Ribble Valley Borough Council
Council Offices
Church Walk,
Clitheroe
Lancashire
BB7 2RA

Your ref: 3/2025/0198

Our ref: 3/2025/0198/HDC/KW

Location: Eaves House Farm Waddington Road West Bradford BB7 3JF
Proposal: Listed Building Consent and Planning Permission for the proposed conversion of Green Barn to create 1no dwelling with associated parking and amenity space. Conversion of Outbuilding 02 to form 2no double garages to serve the proposed barn conversion and Eaves House Farm. Partial Conversion of Outbuilding 01 to form new home office in relation to the existing listed farmhouse
Grid Ref: 373282 444679

6955 - B - P03F

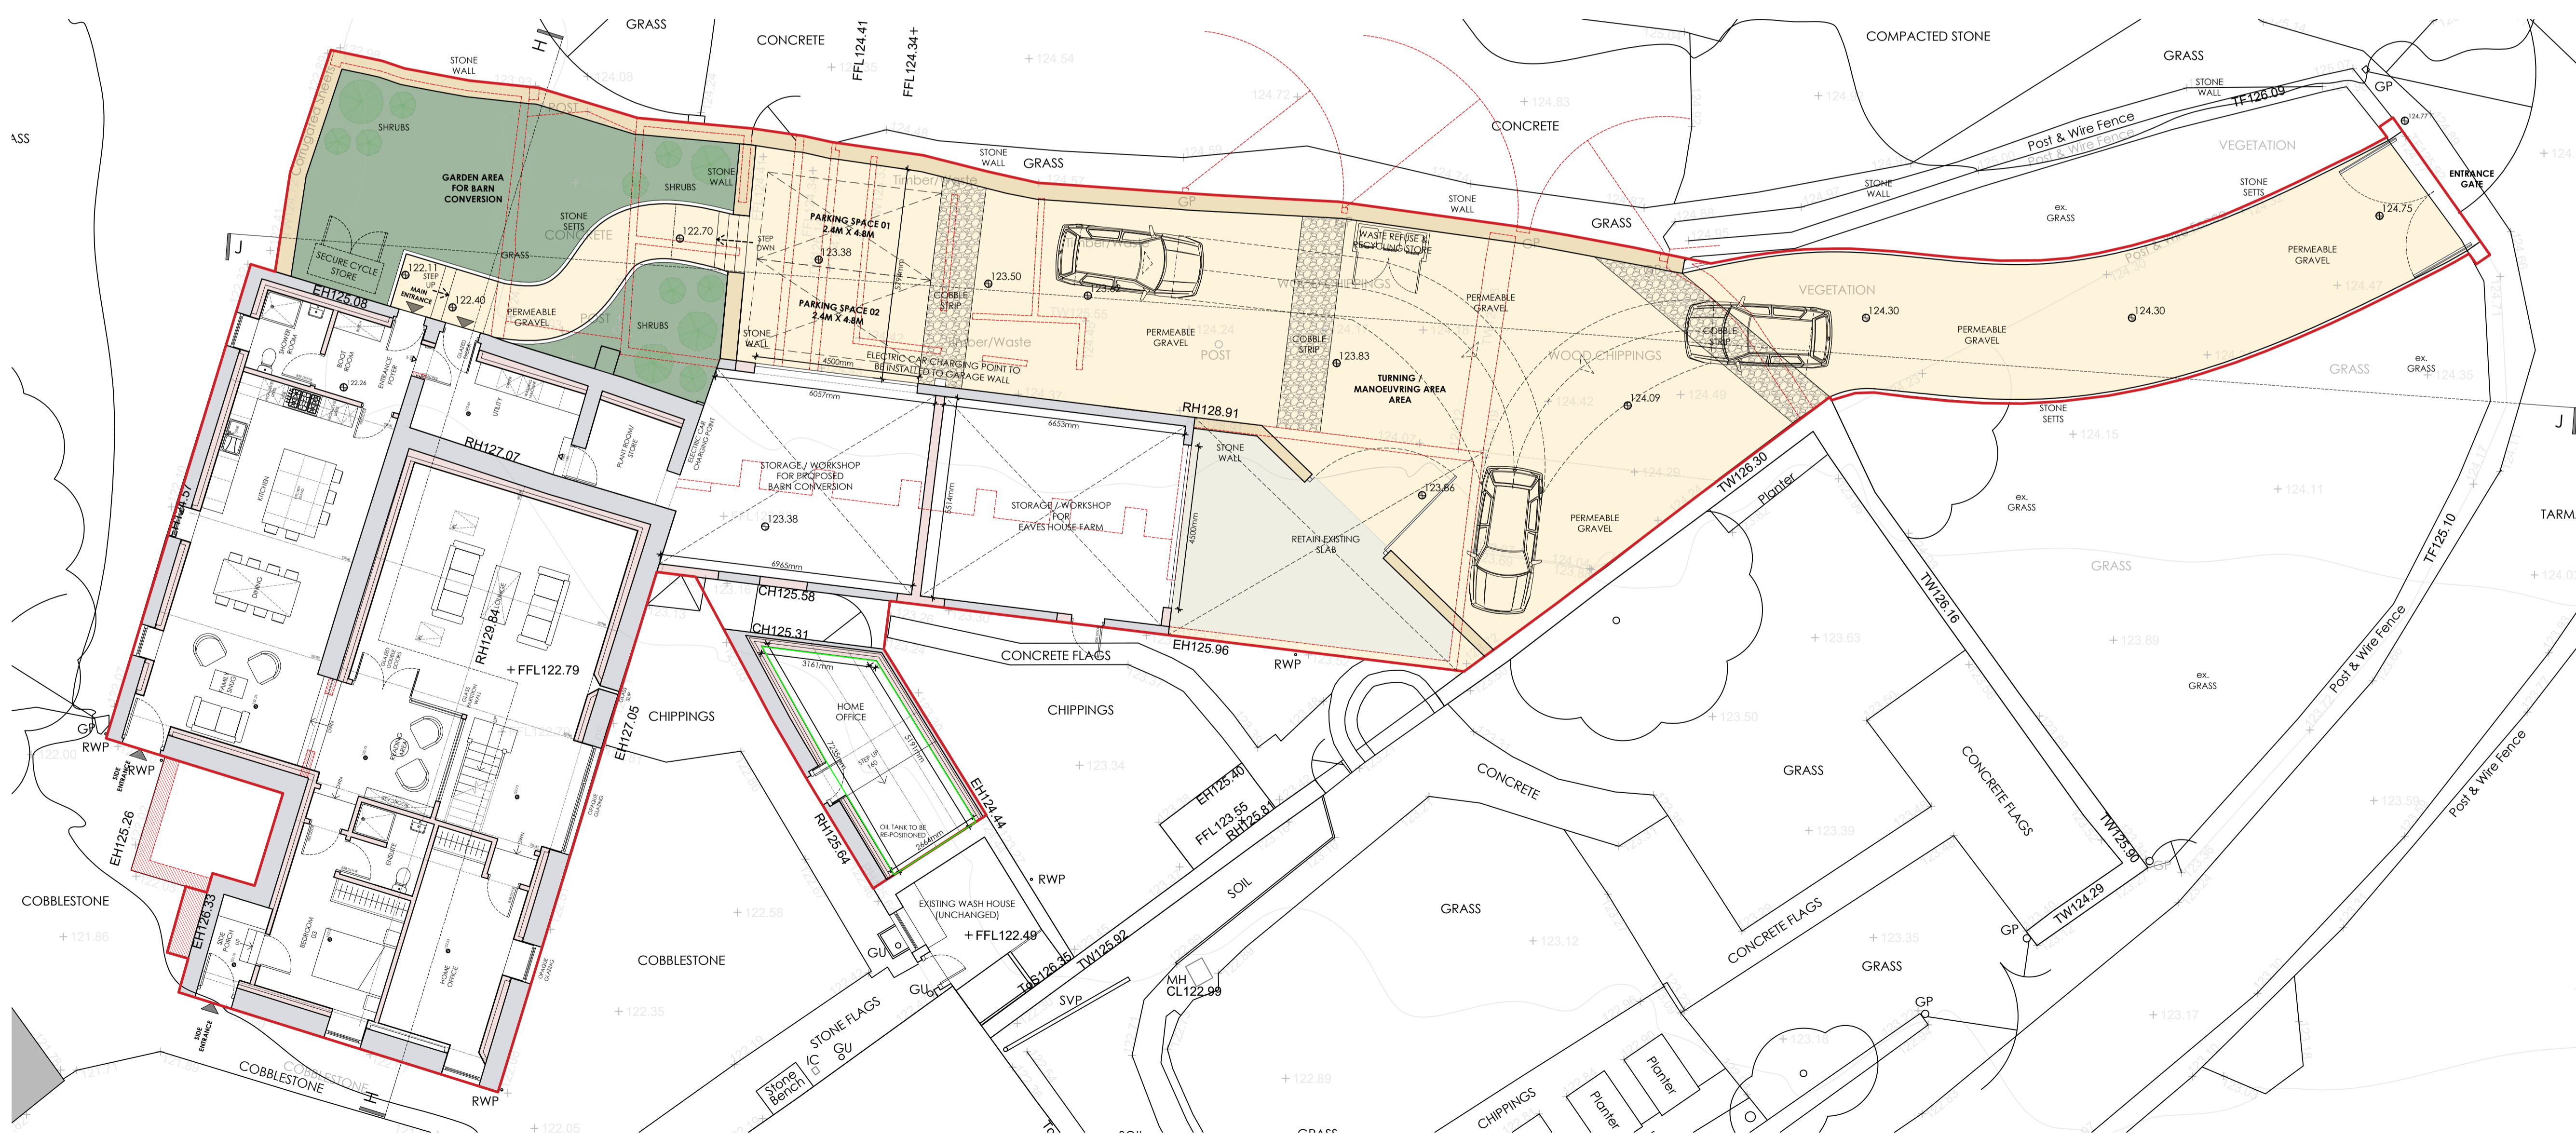
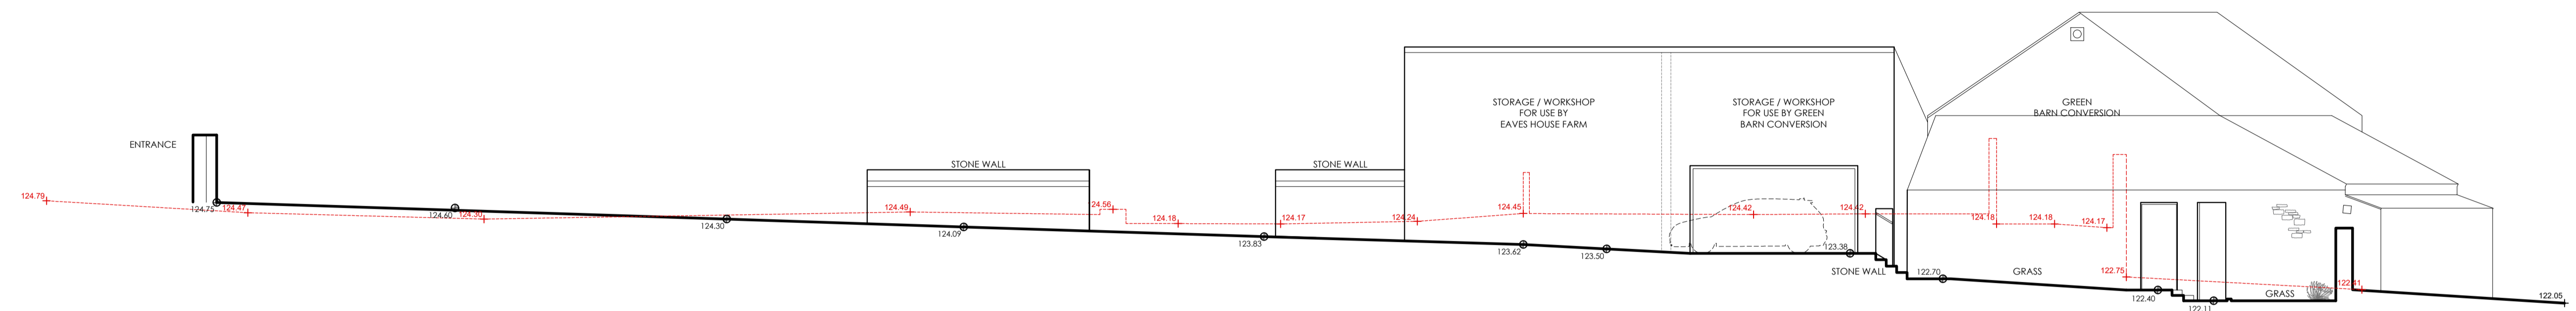
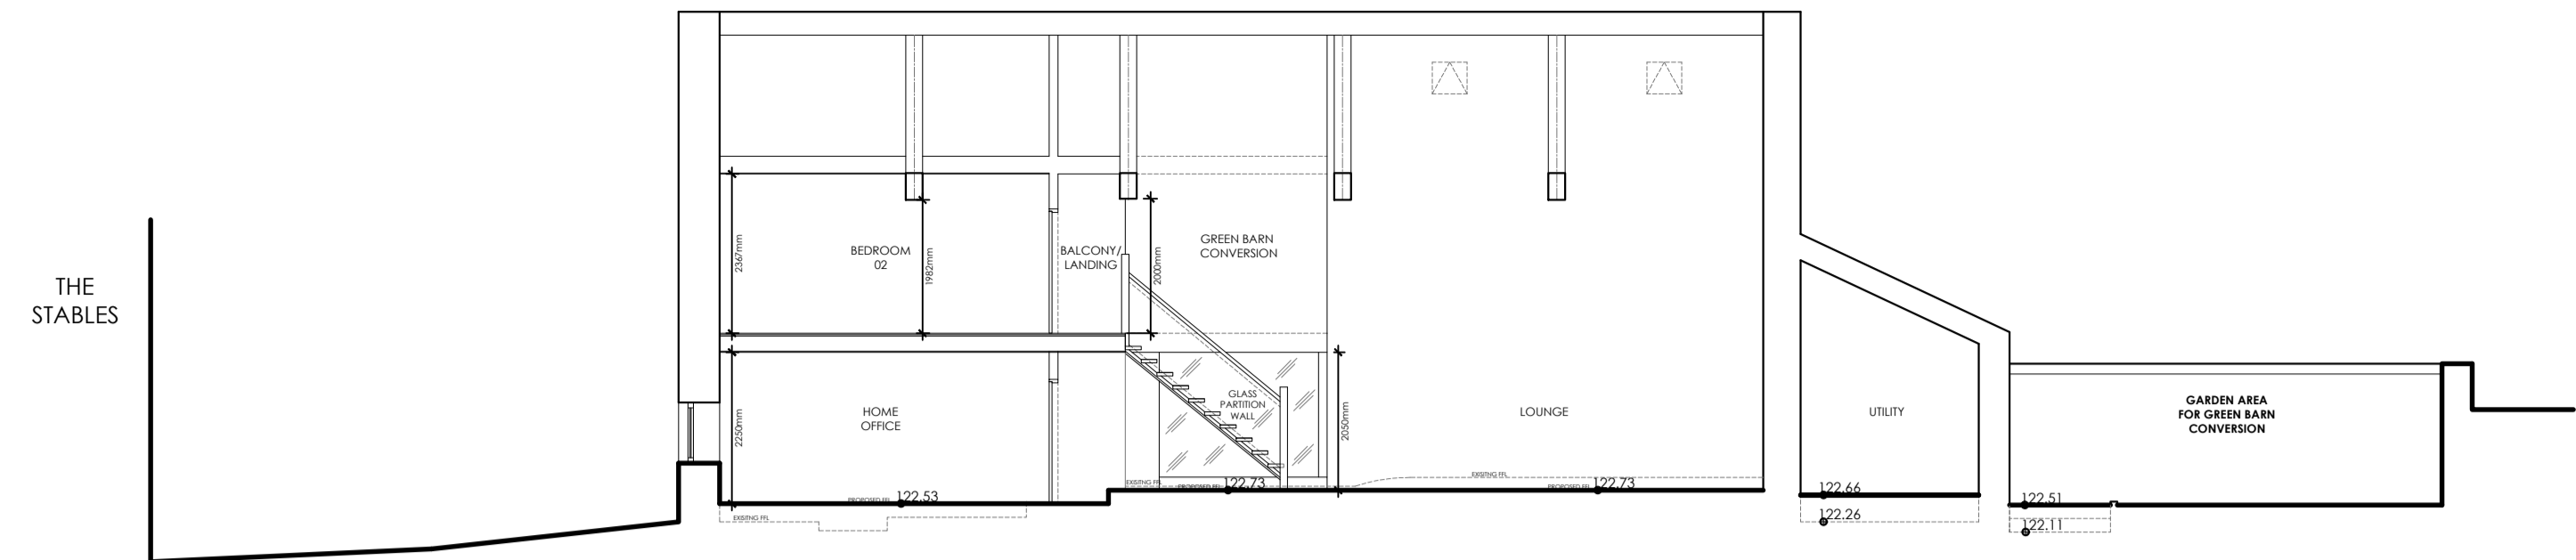
The LHA have reviewed drawing number 6955 B-P03a titled Proposed site plan & site sections and do have some concerns regarding the parking and turning provisions within the site.

The LHA recommended minimum internal dimensions for a double garage size is 6m in length and 6m wide. However the proposed garages are smaller than the recommended minimum internal dimension and as such they should not be counted as a parking space and the applicant should provide an additional parking space for each garage affected.

It is unclear if Eaves House Farm has its own separate parking area that is not included within the drawing and the parking requirements for its size have not been made available; as such the applicant should detail parking provisions for the existing farmhouse to ensure the development does not conflict with the existing needs.

As the proposed dwelling has 3 bedrooms, 2 parking spaces are required to be provided in line with the parking standards detailed in the Joint Lancashire Structure Plan. Given the single track nature of the private access track and that the access meets a C classified road vehicle within the site must be able to turn and leave in a forward gear as such alternative parking provisions for both dwellings and turning facilities should be shown on an amended plan. These spaces should measure 2.4m x 5m where they are adjacent to a fence or similar obstruction an additional width of 0.6m should be provided.

The LHA require a passing place to be provided which should be 2.5m wide and 10m long.

The proposed garages fall below the recommended minimum dimensions of 6m x 6m, meaning they cannot be counted as parking spaces. Additional parking must be provided accordingly. The applicant should also clarify whether Eaves House Farm has separate parking provisions to the proposed garages. For the proposed dwelling with three bedrooms, at least two parking spaces are required, each measuring 2.4m x 5m, with an additional 0.6m width where adjacent to an obstruction. Given the single-track nature of the access, all vehicles must be able to enter and exit in a forward gear. The site layout should be amended to ensure adequate turning space alongside parking provisions are available.
